April 5, 2016

**RE: Amended Subdivision Plan & Level III Site Plan Application  
Schlotterbeck Block – 117 Preble Street**

Title: **GRADING, DRAINAGE AND UTILITIES PLAN**

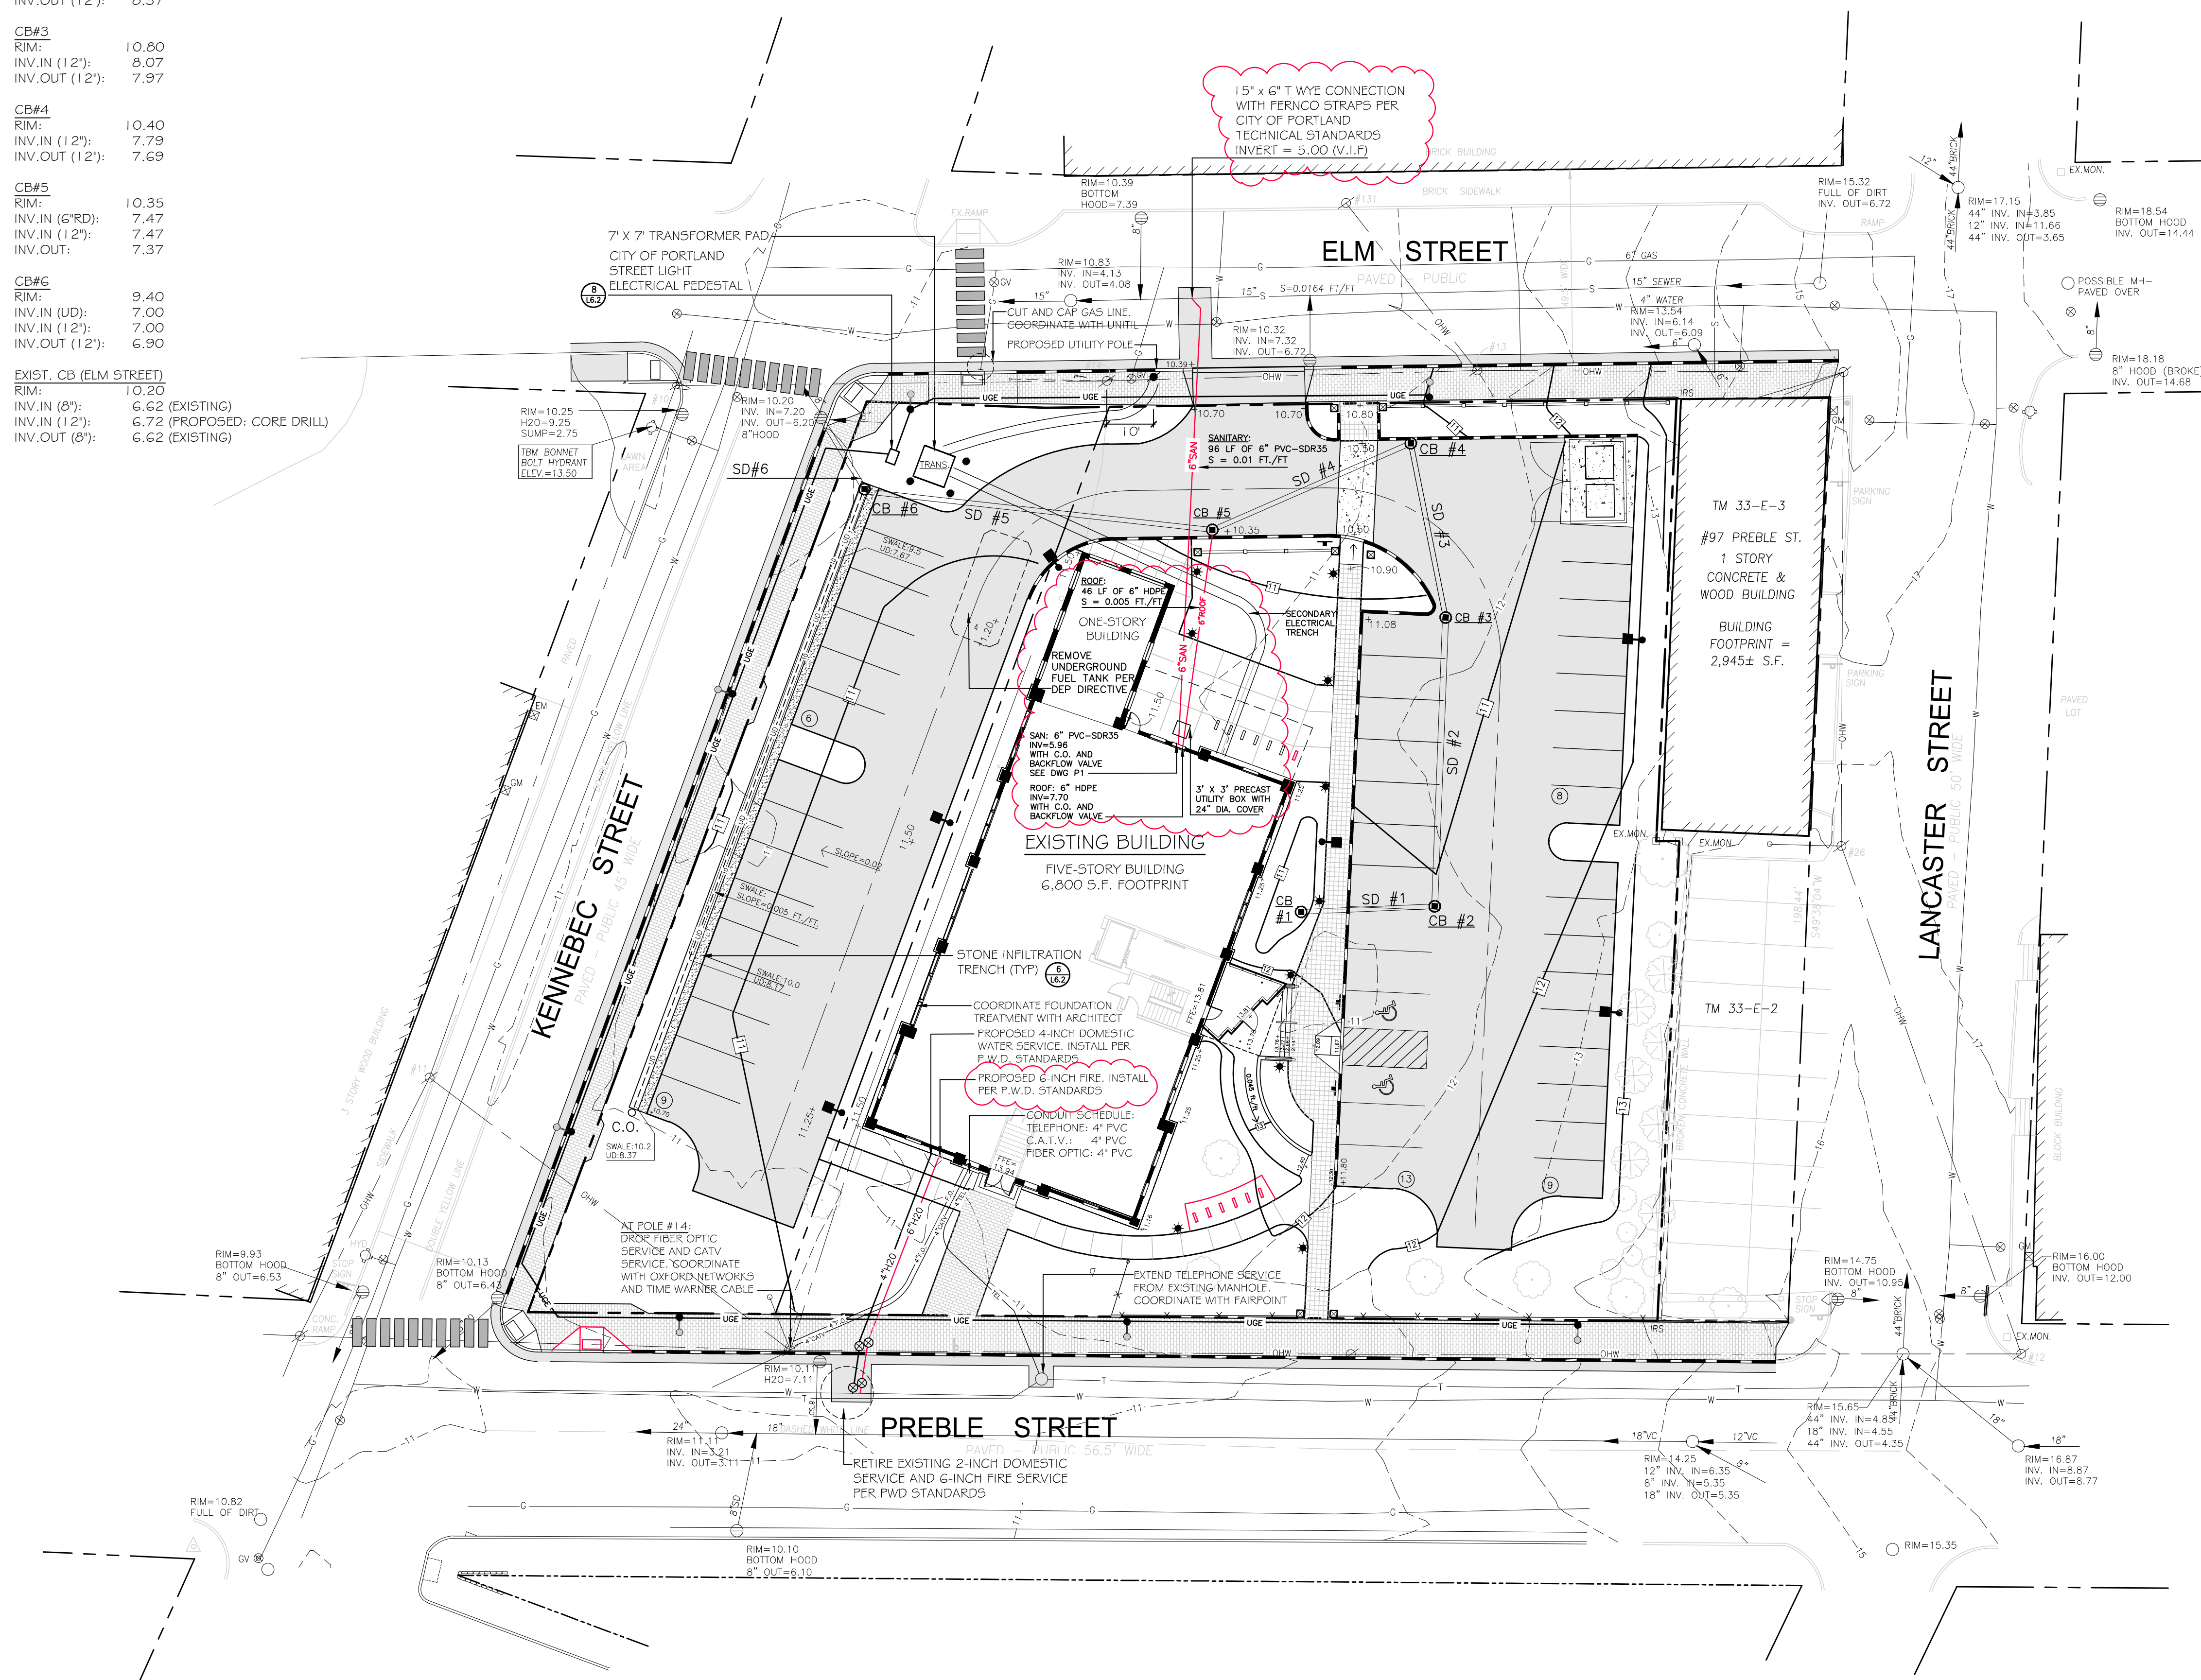
5. **6-inch Fire Water Line**: Attached revised L3.0 adds a new six-inch fire suppression water line from Preble Street to the building's fire suppression system. The applicant had planned to continue using the existing 6-inch fire suppression line, but existing 6-inch line is in poor condition.

6. **Roof Drain Connection**: Attached revised L3.0 shows a new 6" HDPE roof drain connecting to catch basin #5. The existing roof drain pipe is in poor condition and needs to be replaced.

7. **Sanitary Sewer Line**: Excavation exploration revealed the existing 6-inch cast iron sanitary sewer line is in poor condition. The applicant proposes to replace the existing sewer line with a new PVC sewer in approximately the same location and wye connect the 15-inch combined sewer on Elm Street.

2 SIDEWALK RAMP: KENNEBEC STREET AND PREBLE STREET (NORTH)

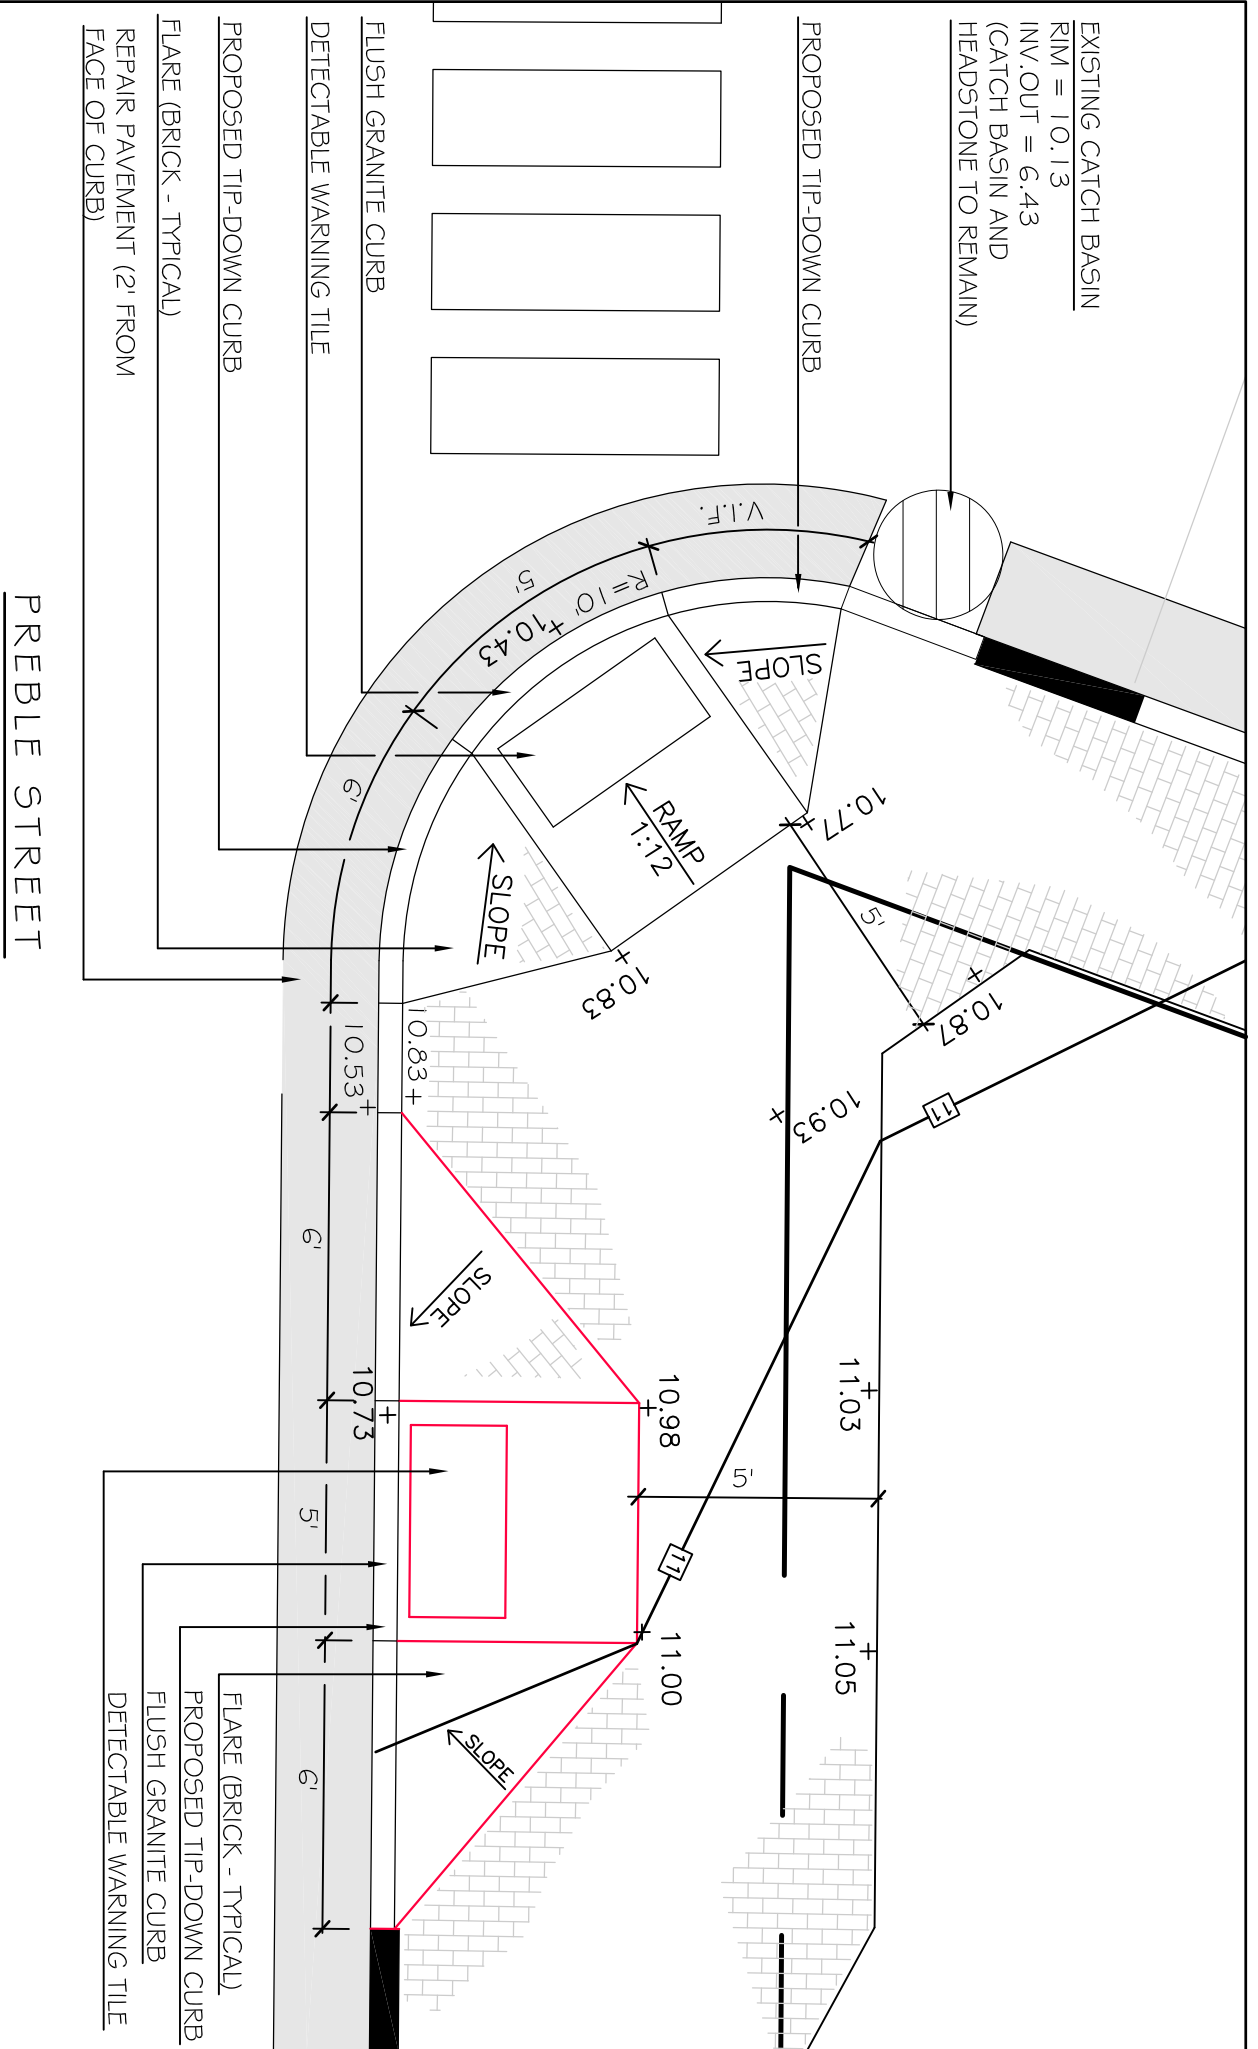
4. **Additional Sidewalk Ramp and Pedestrian Easement**: The City's staff has requested an additional sidewalk ramp at the intersection of Preble and Kennebec Streets, as part of the December 2015 conditions of approval. The new ramp will require pedestrian easement on the applicant's lot. The attached Amended Subdivision Plan and sheet L2.0 show the new sidewalk ramp and the pedestrian easement. Also, attached Exhibit B also shows the detailed layout and grading the new sidewalk ramp.
